ASSESSMENT REPORT

Section 96(1A) Modification Kings Park Metal Recovery (SSD 5041 MOD 1)

STREETVIEW ELEVATION  
TATTERSALL RD

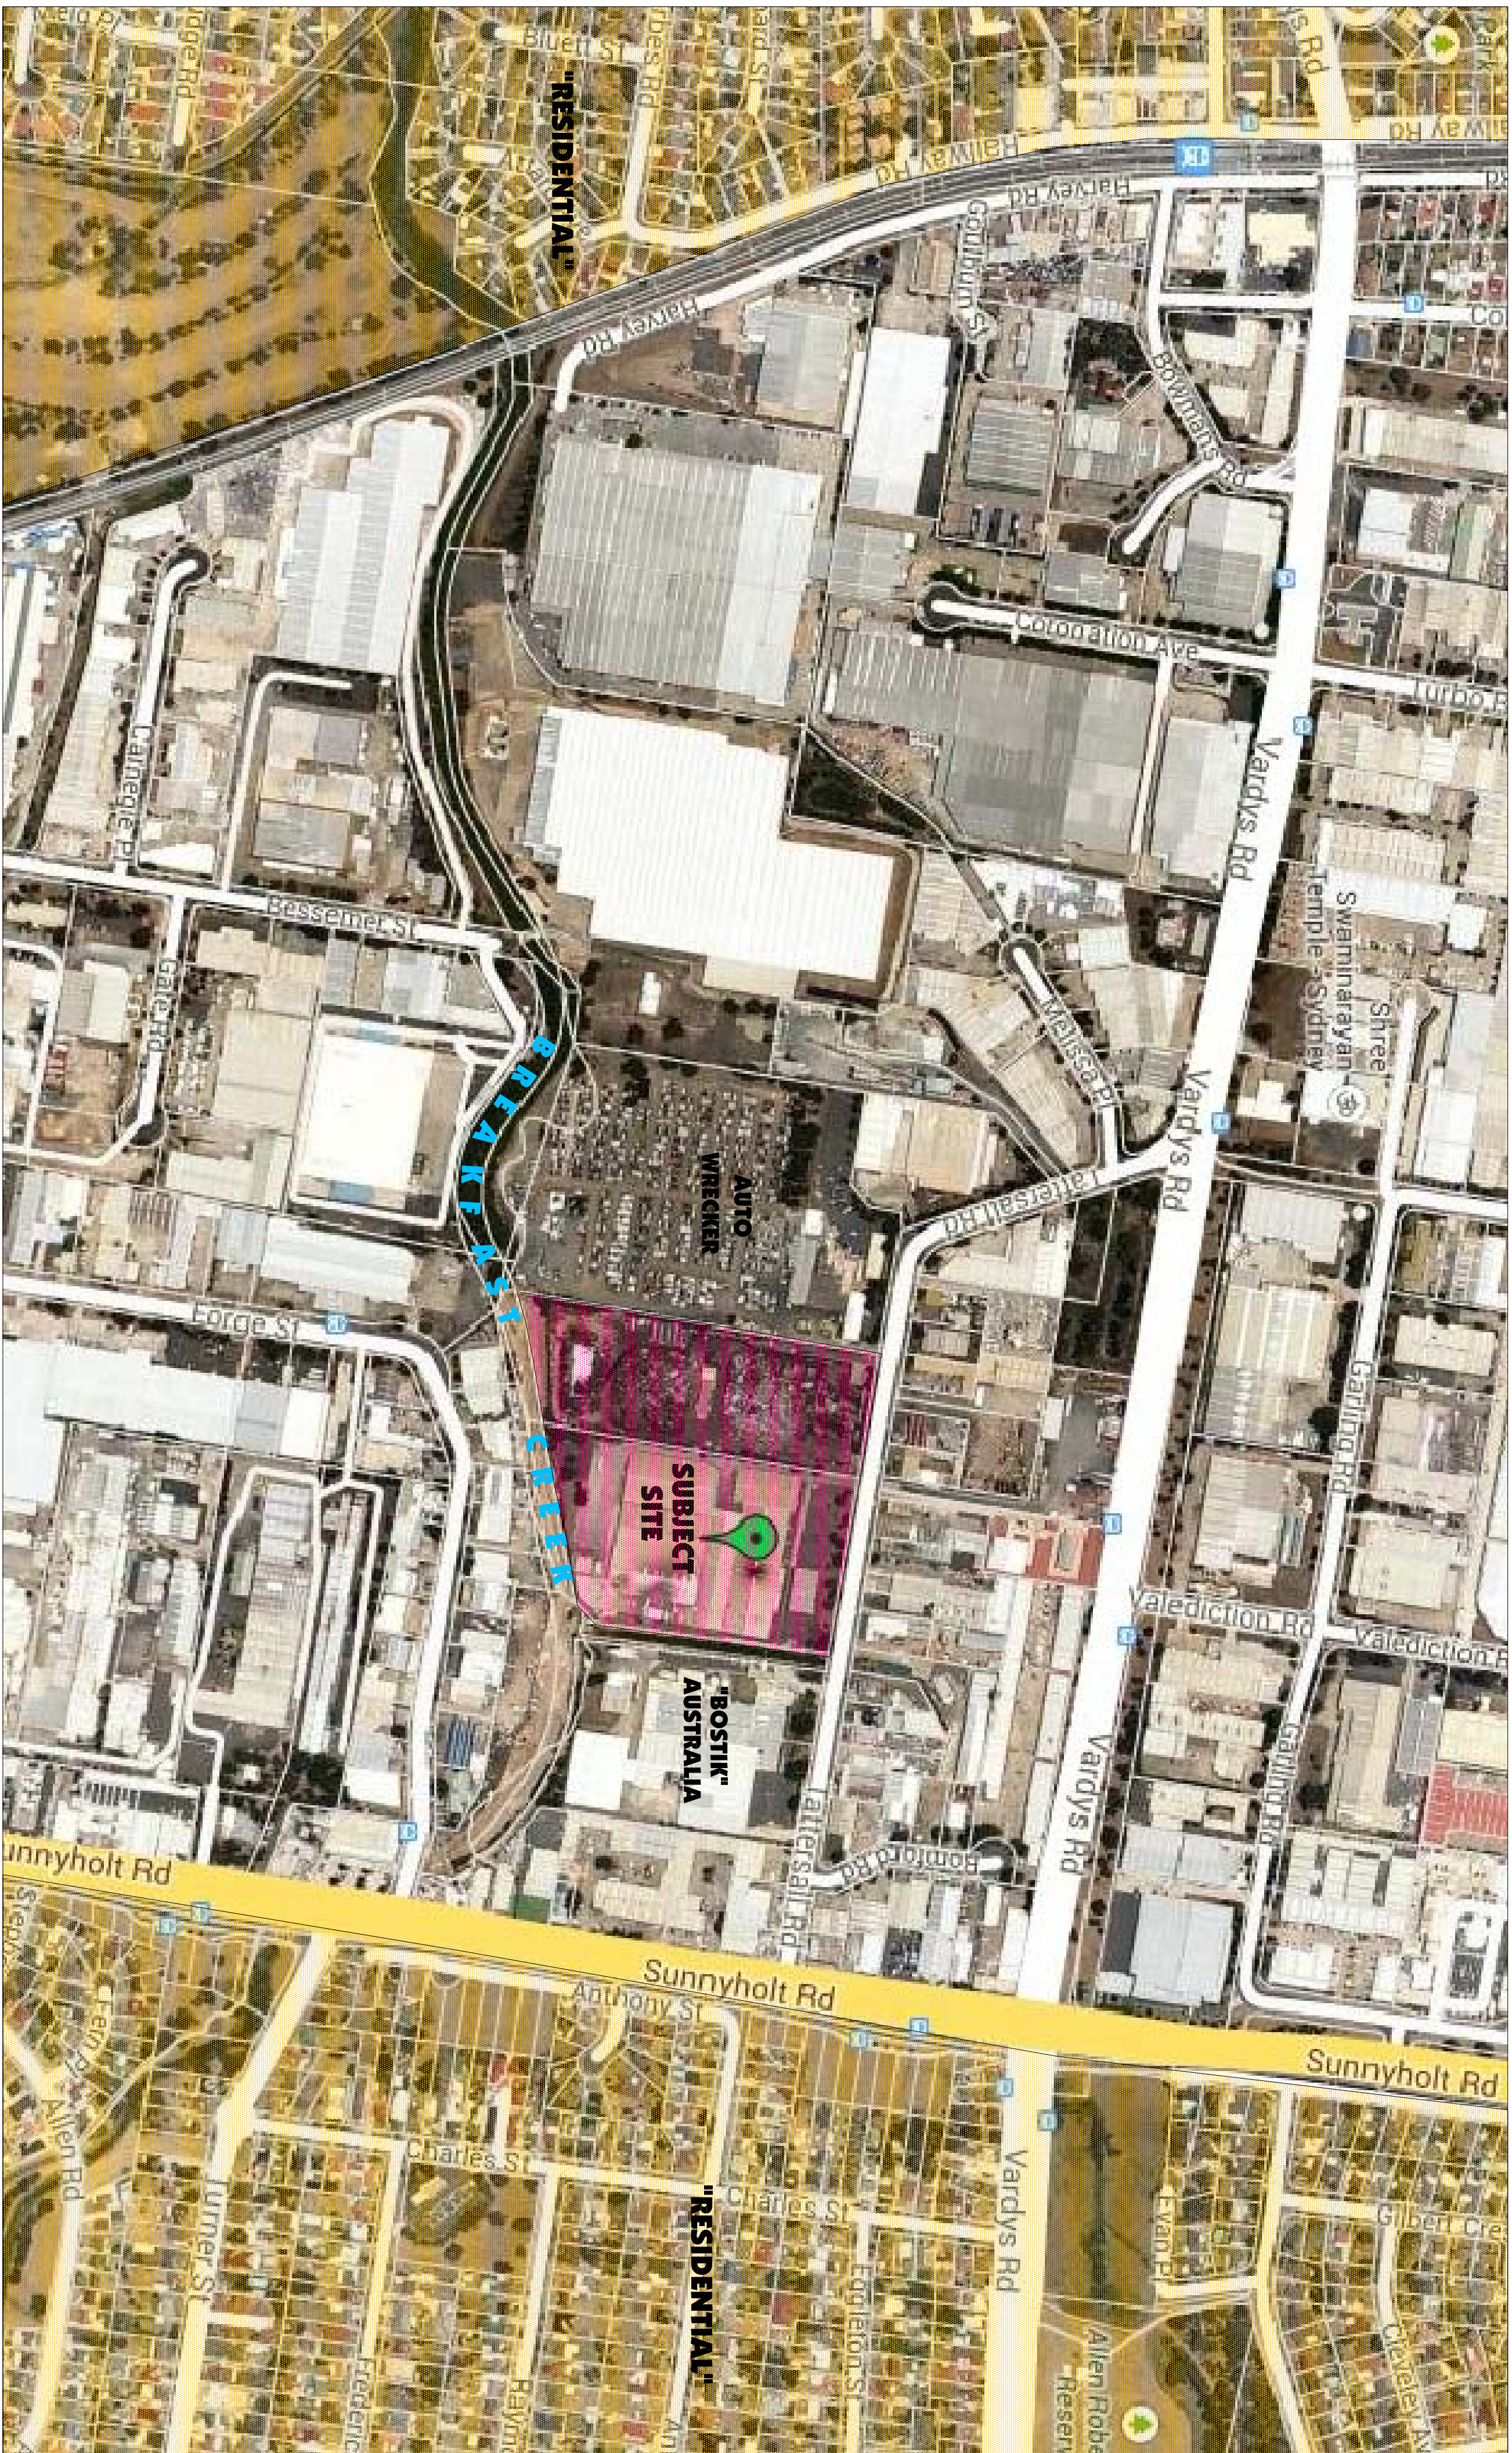
In its submission, Council raised concerns regarding the amended height of the proposed awning (from 10 m to 15 m in height). Council suggested the location of the awning at the boundary of Tattersall Road will have an imposing effect on the streetscape. Council also requested that the details of the external finishes and treatments of the awning be provided to ensure methods to assist in breaking up bulk and scale of the structure are utilised.

In a report responding to the submissions, the Applicant addressed Council's concerns by stating the external finish of the awning will encompass prefabricated "heritage green" steel panels. The Applicant also suggested the view of the awning structure from Tattersall Road will be screened by existing mature trees and acoustic wall.
